**Turf Masters LLC
Variance of Use
Letter of Intent**

November 20, 2024

PCD File No: VA248

TURF MASTER VARIANCE OF USE

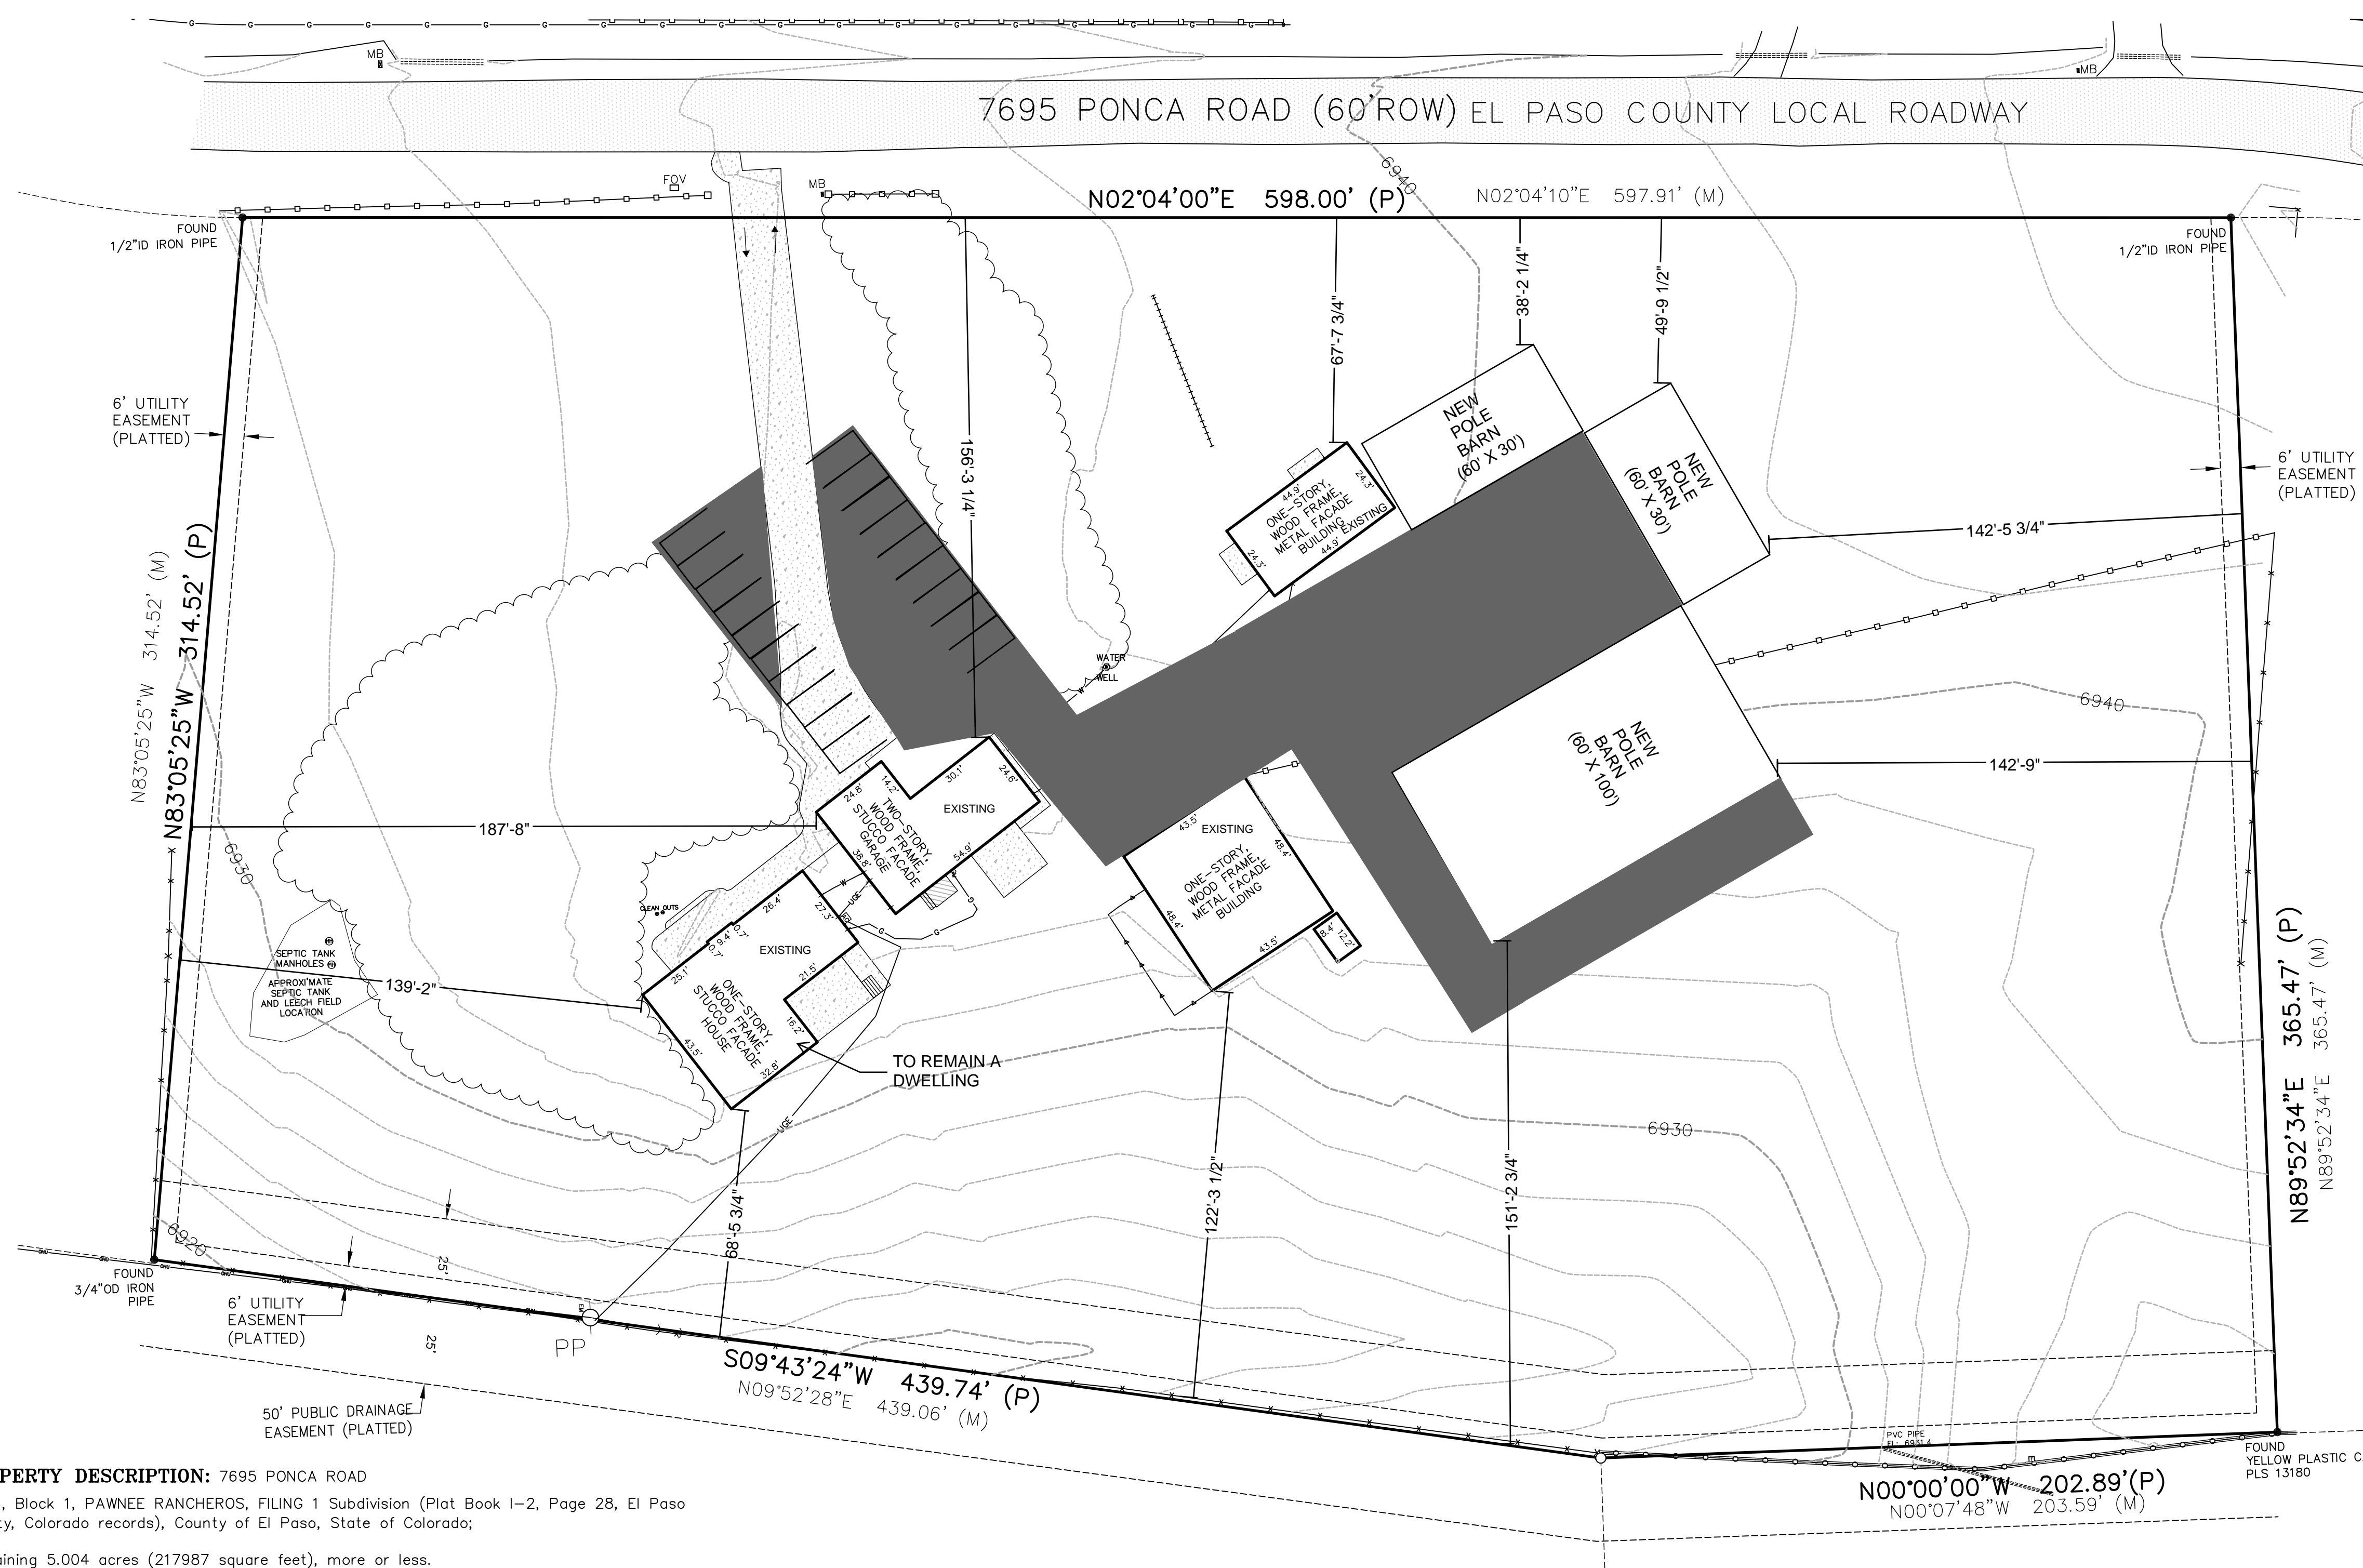
Please identify as proposed structures as proposed.

Inconsistent with site plan

The site plan shows a total of 7 structures. While understanding that one is for the existing home, does this mean the owner is not using the other structures on site? Please explain if the existing structures will remain empty or will they be used for the business?
